Our Reference: SYD17/01651\_2 & SYD17/01653\_2  
Your Ref: SSD8925 & SSD8925

**PROPOSED NEW SYDNEY FISH MARKET  
STAGE 1 CONCEPT WORKS AND STAGE 2 MAIN WORKS  
1A TO 1C BRIDGE RD, GLEBE & PART 56-60 PYRMONT BRIDGE ROAD, PYRMONT**

Roads and Maritime has reviewed the submitted application does not provide concurrence for the proposed development application. The following additional information shall be provided:

Longitudinal Section - MC00

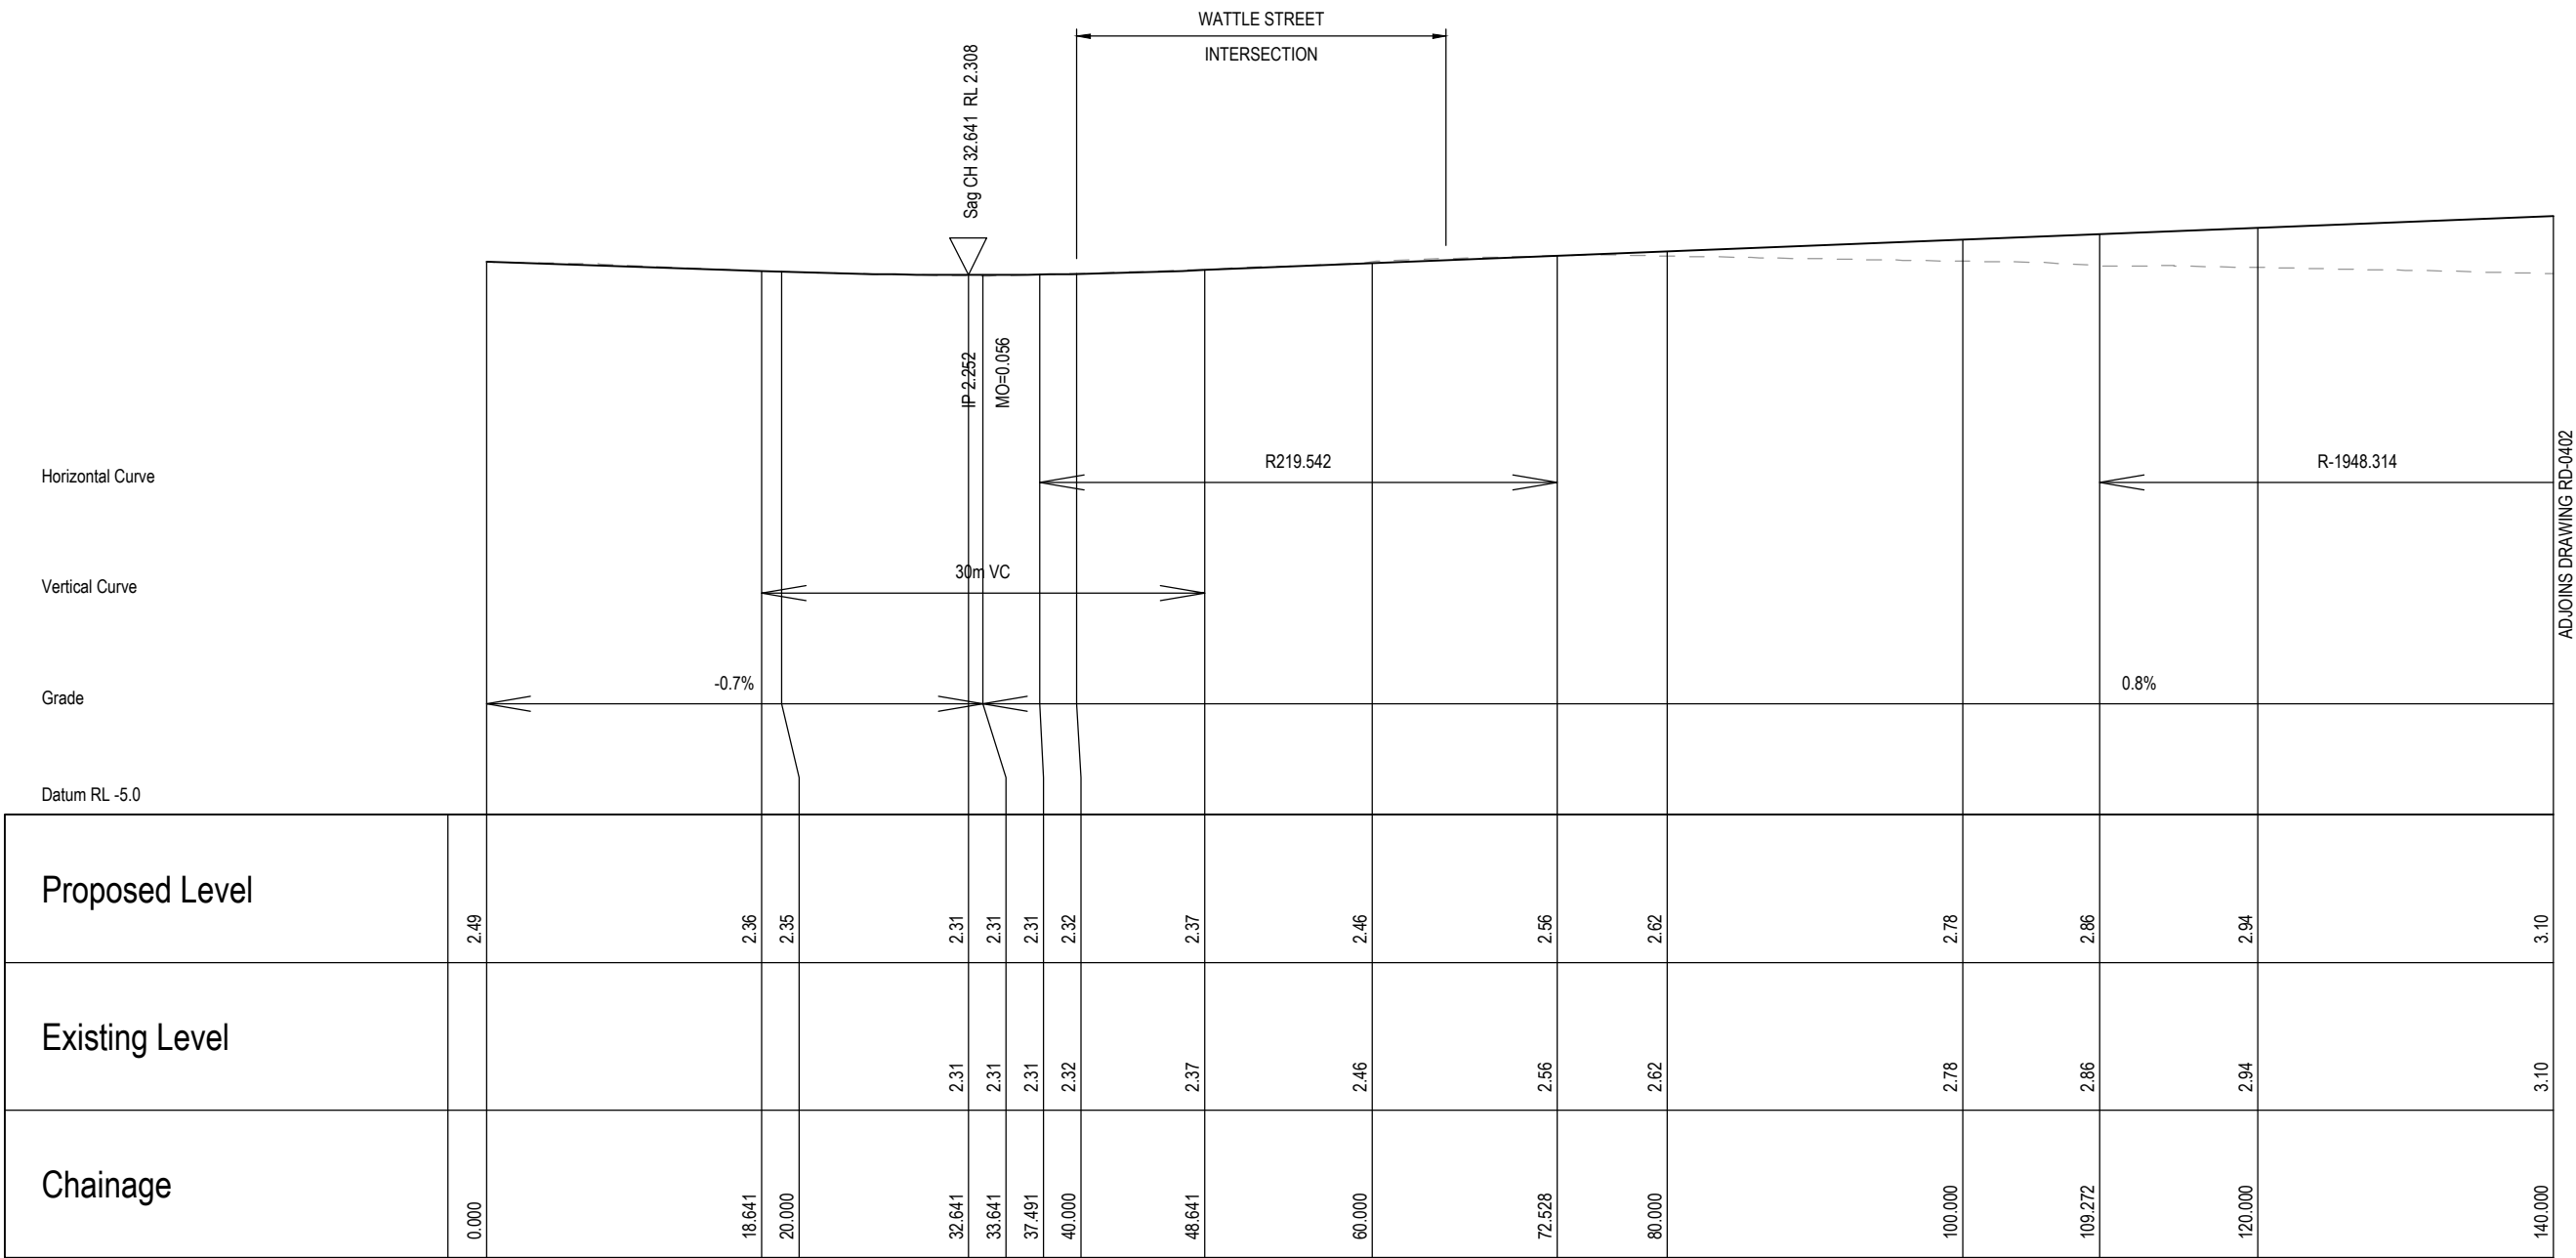
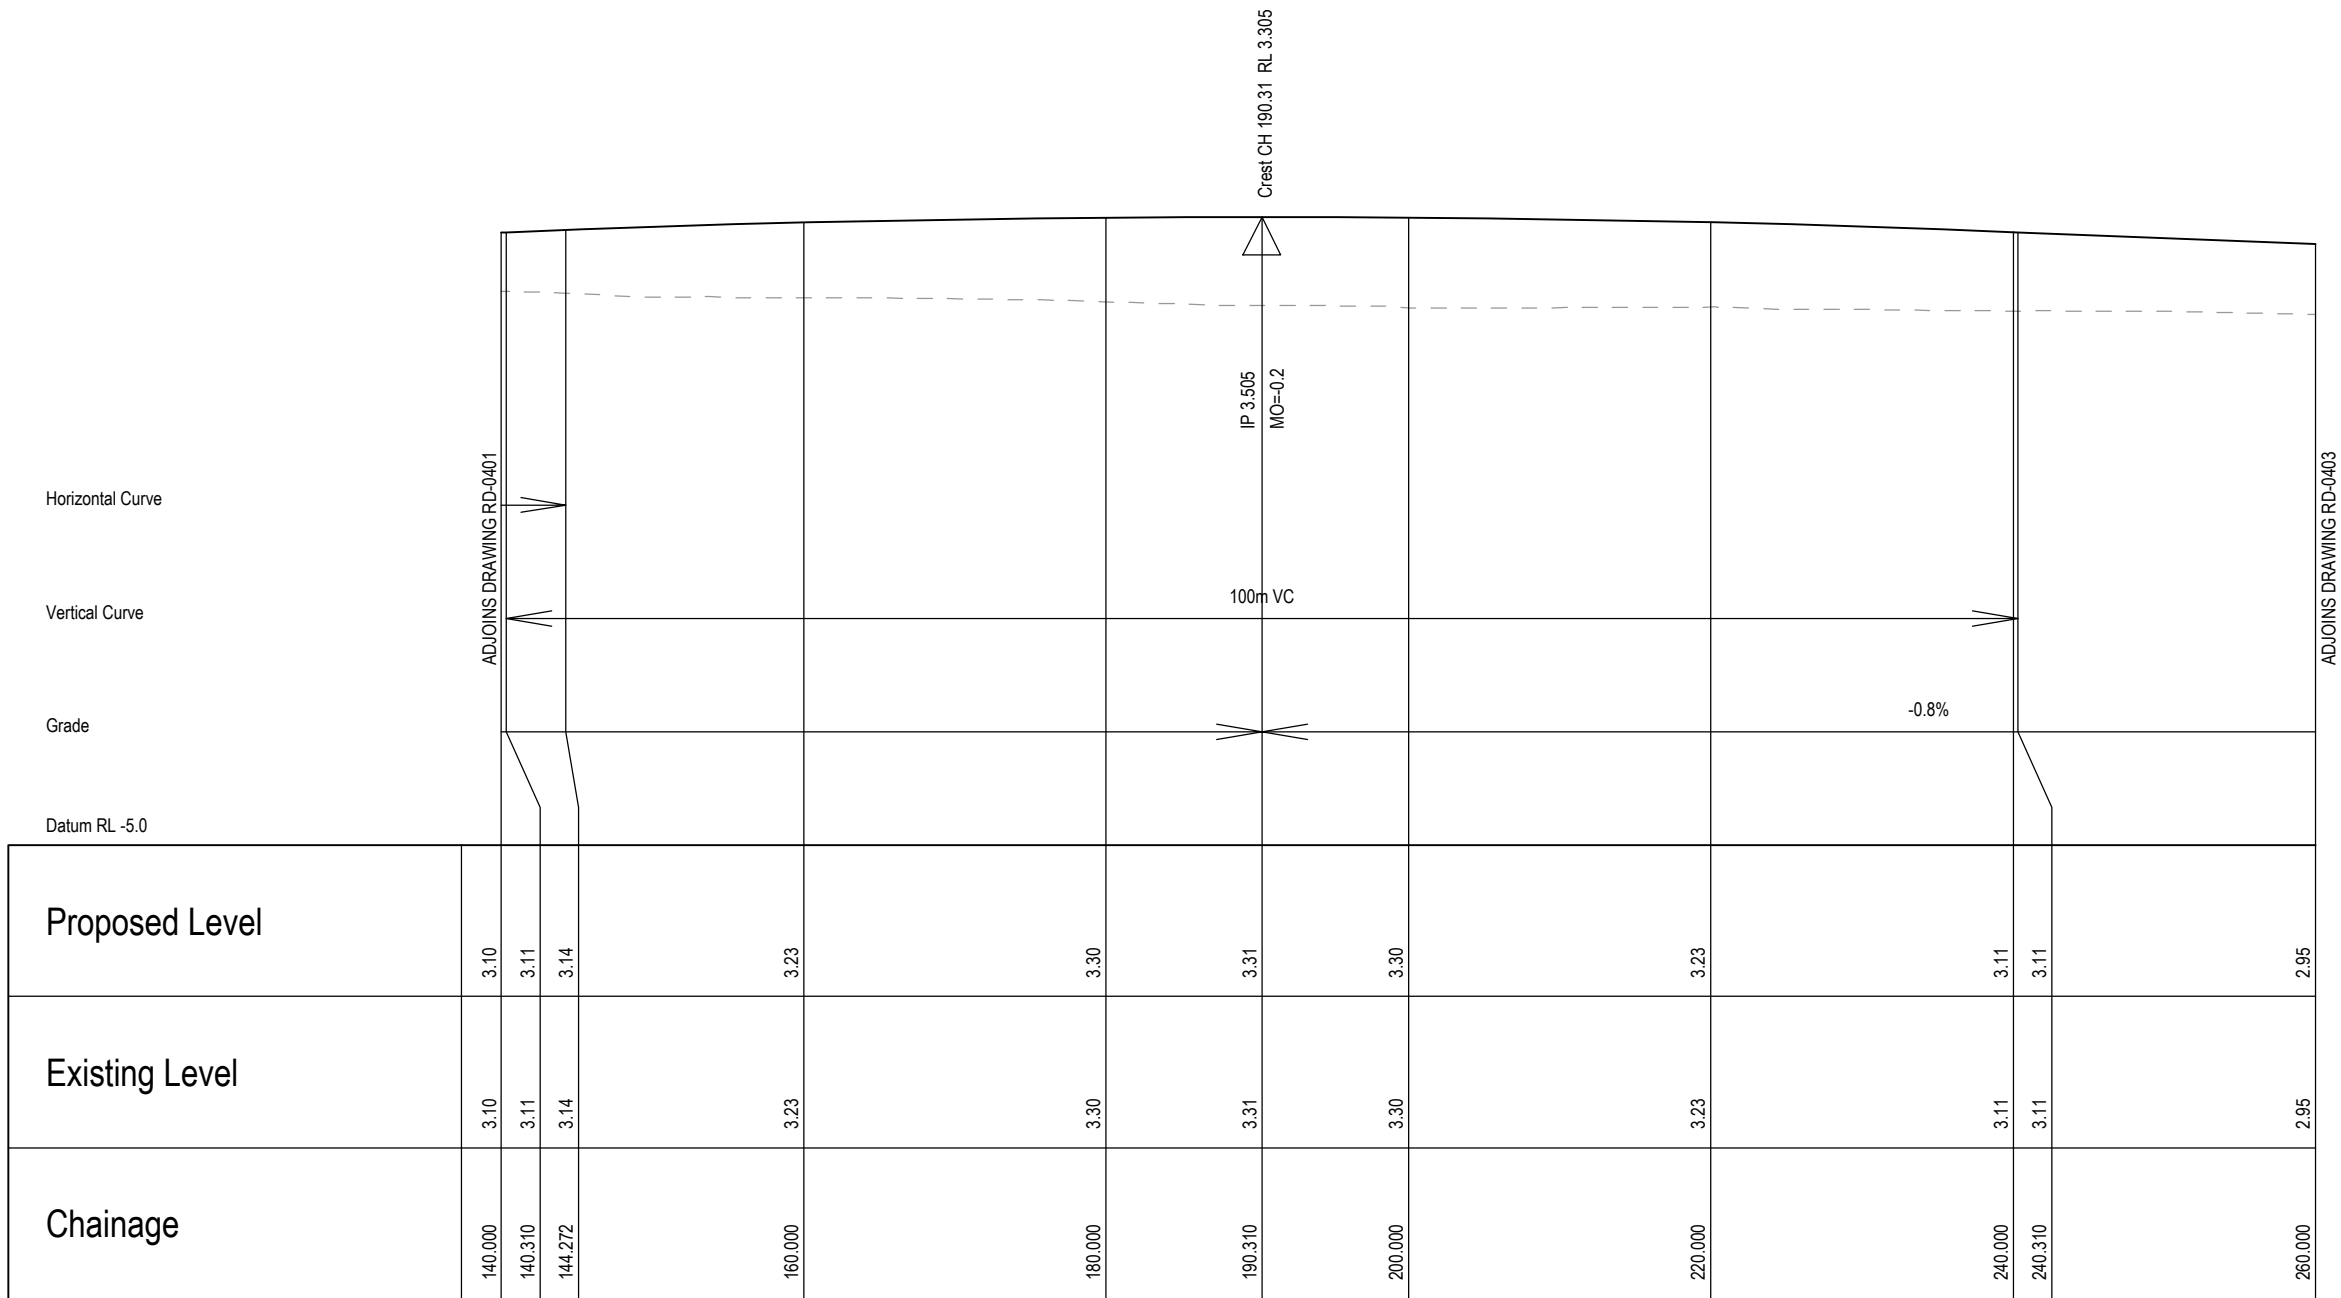
10. The proposed increase in road level along Bridge Road between Wattle Street and Wentworth Park Road will require removal of a significant amount of foliage from the established Moreton Bay fig trees. These are considered to be highly important to the community and should be protected where possible. Furthermore the increase in finished levels along Bridge Road will potentially exacerbate localised flooding on the surrounding road network.
